From: Simon Davis
Sent: 25 April 2014 09:36
To: [REDACTED]
Subject: RE: Application P/38/14/HH 10 Manor Park, Pagham

sheet 2 of 3

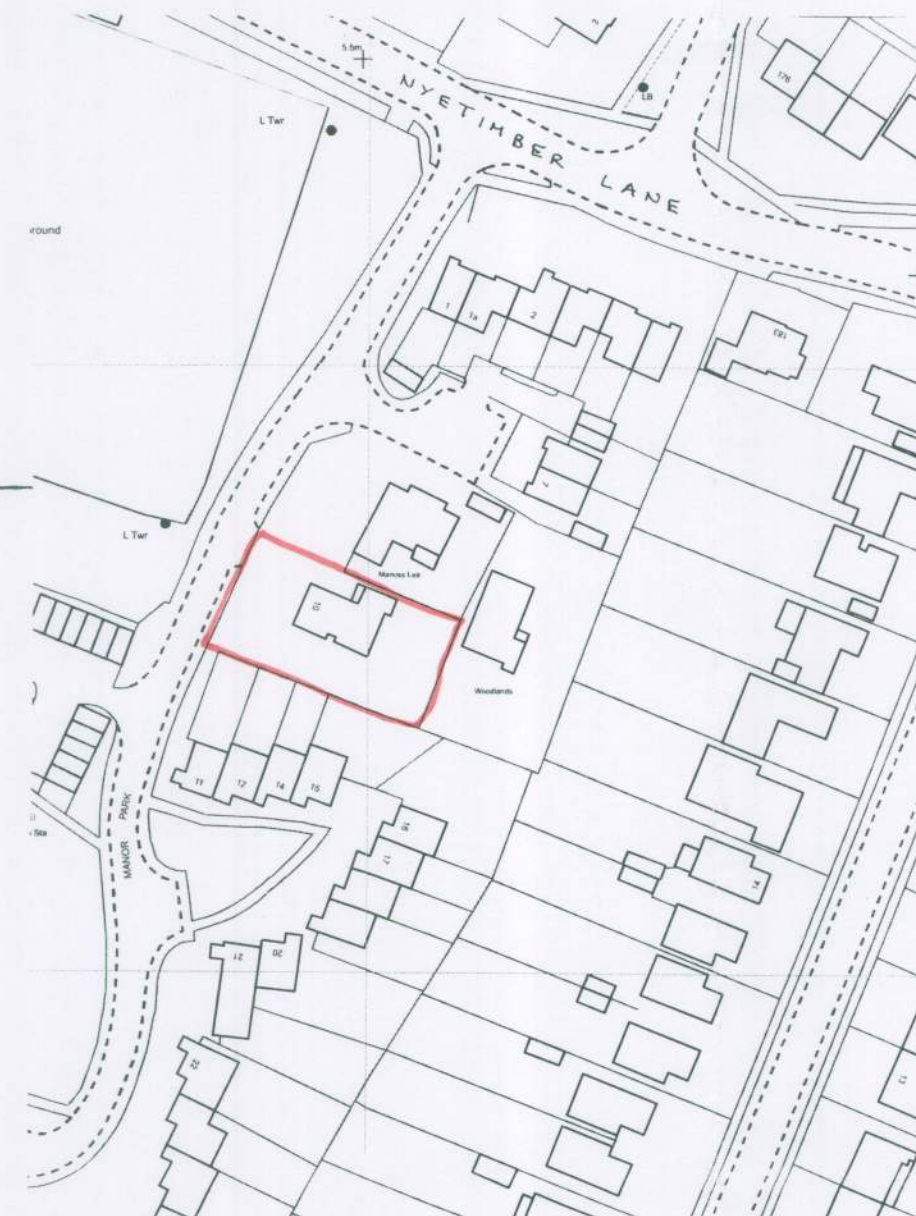
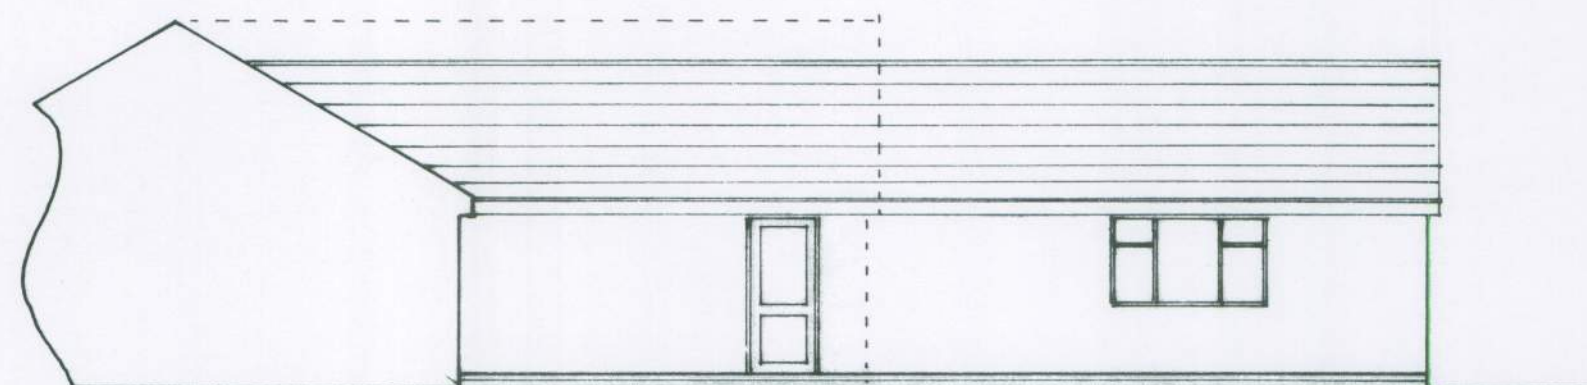
I've been out to look at this application today and then discussed it with Daniel Vick. We do not consider that we are able to support the proposed depth of forward extension based on the impact on the streetscene and on neighbouring properties. We would be able to support an extension as deep as the existing forward projection so your client could have the extra bedroom and bathroom but not the lounge/kitchen. Would your client be in agreement with an amendment? Otherwise we shall refuse the application.

I also have a concern over the proposed flank bedroom window. I observed that the boundary treatment of 11-15 Manor Park is not particularly high and I suspect that there could be direct overlooking over the top of the boundary from the new bedroom to the back of 12 or 14. If your client is able to increase the height of the boundary or make the window high level and obscure glazed then this might be acceptable. You could then place an alternative/second window on the opposite flank wall close to the front door.

sheet 1 of 3

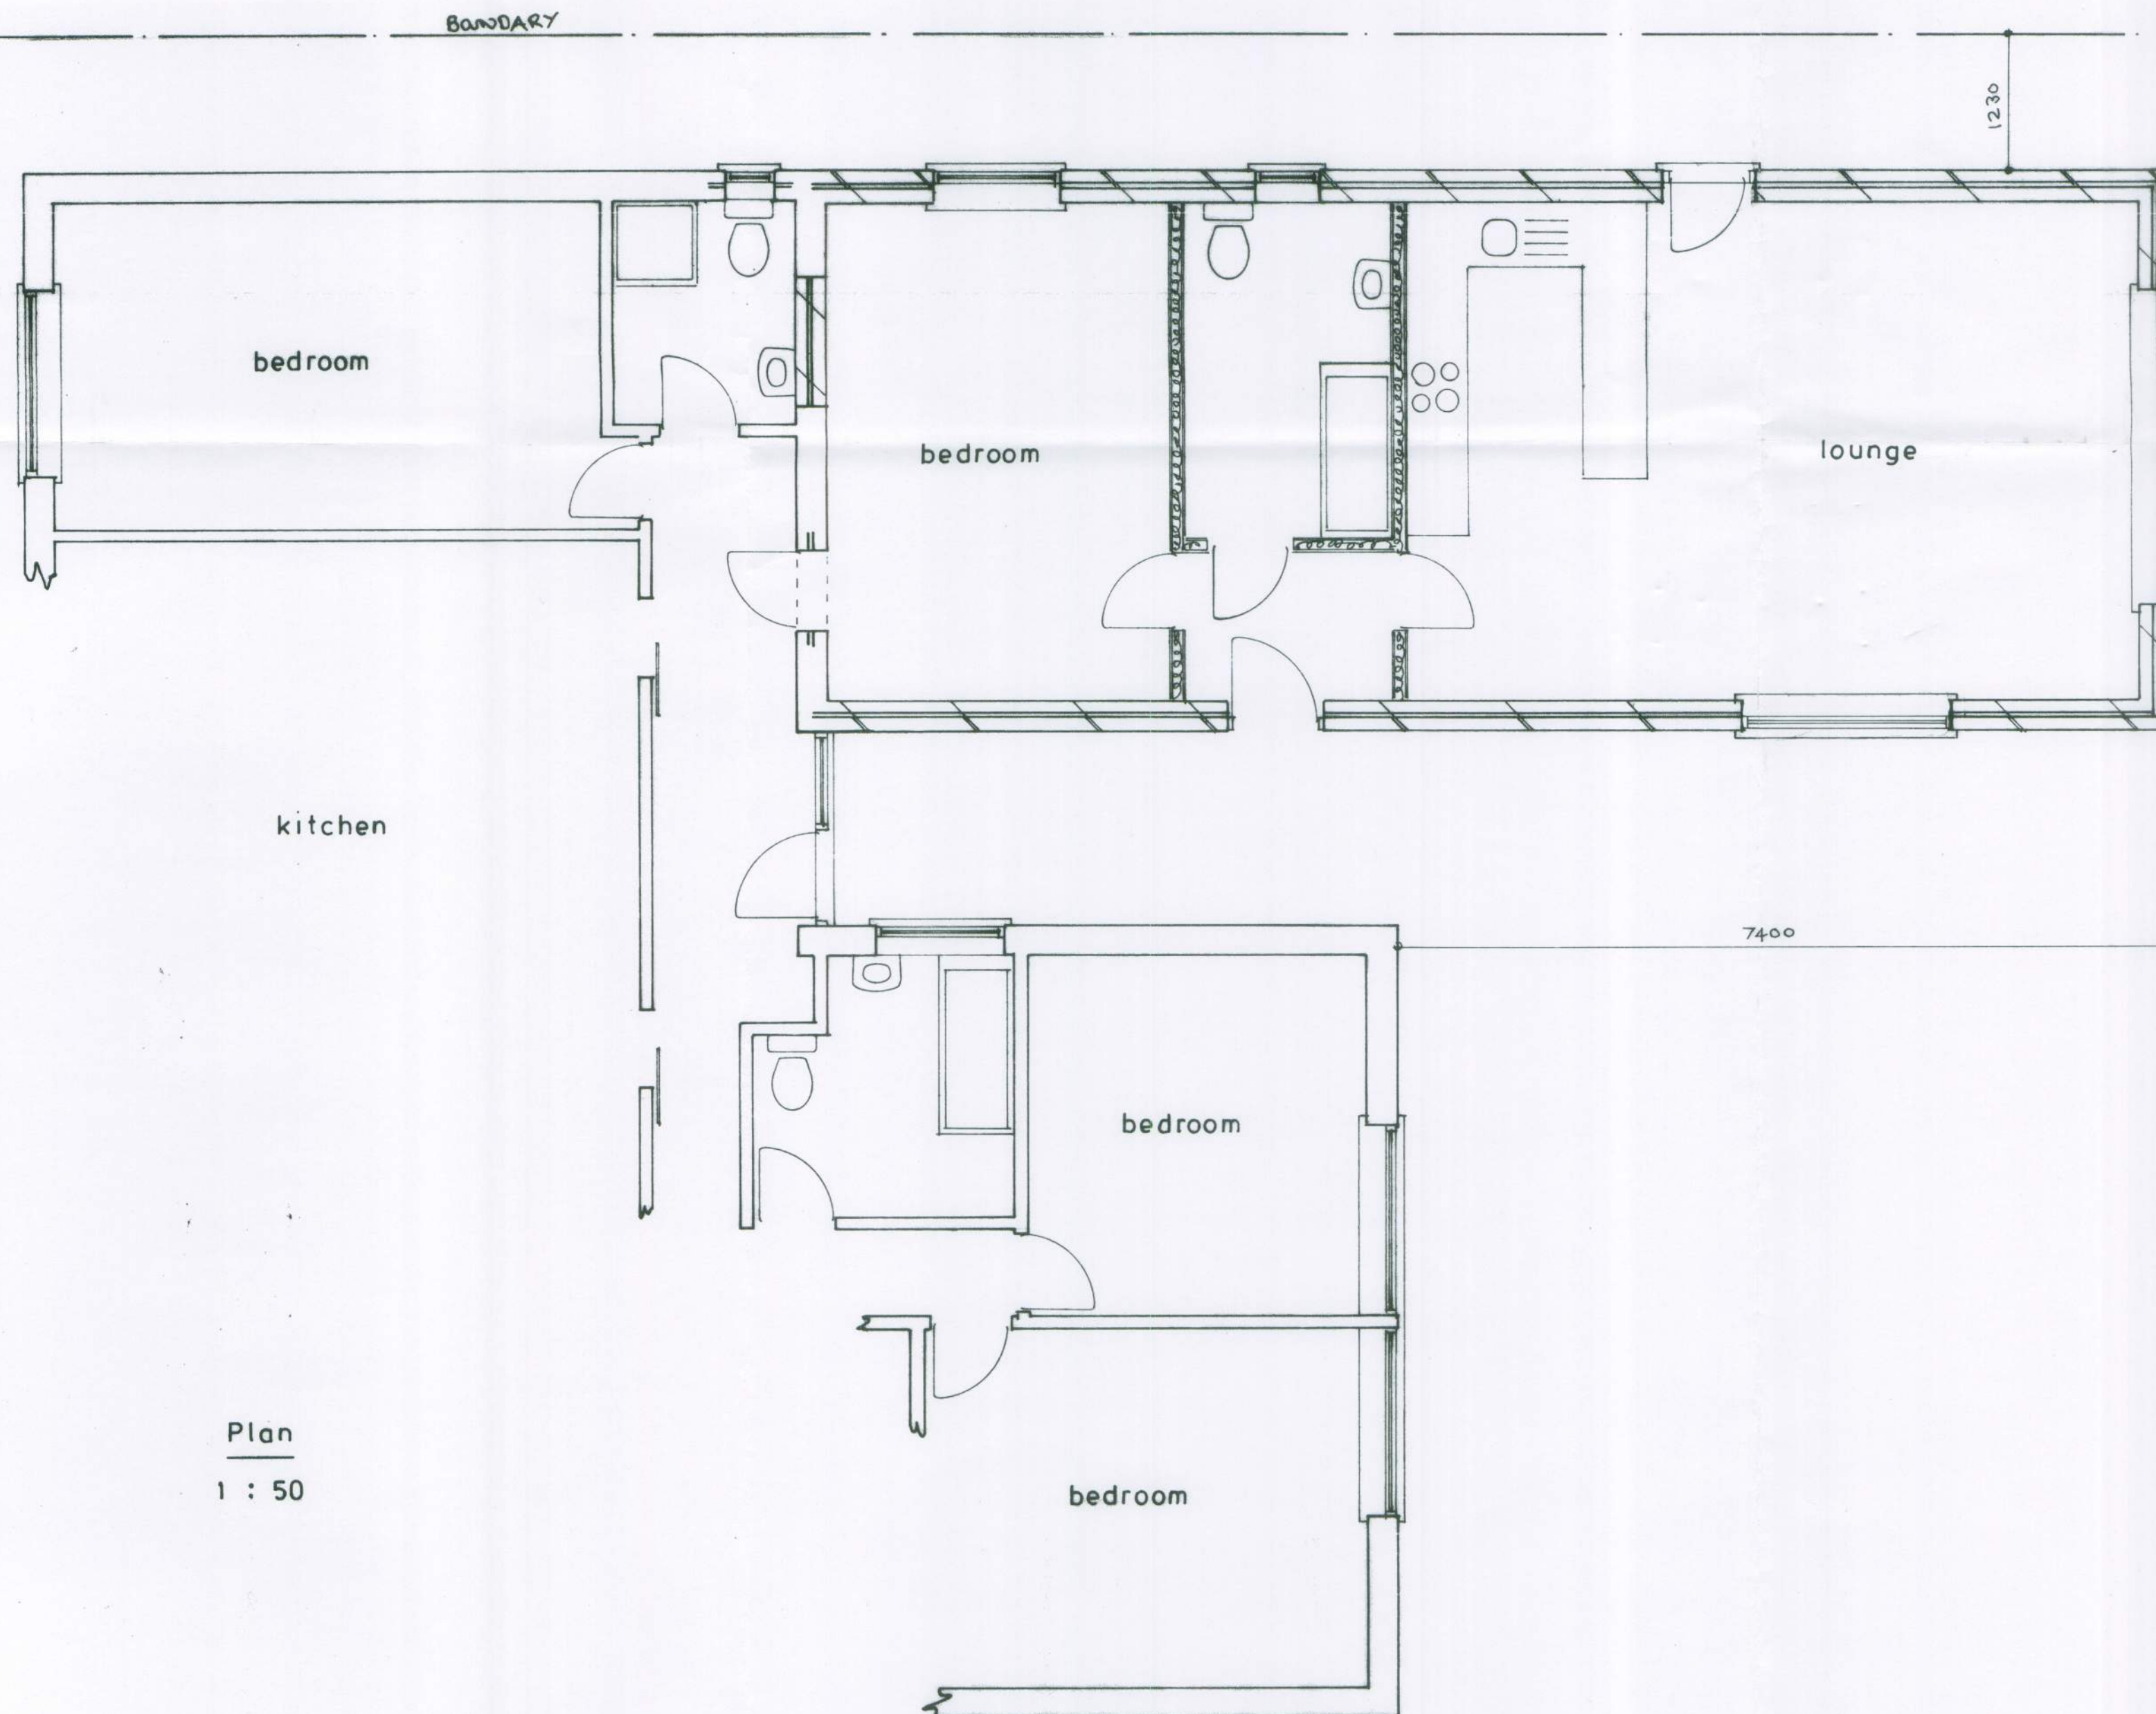
I don't consider we would allow a conservatory on the end. A conservatory would be more suitable on the rear.
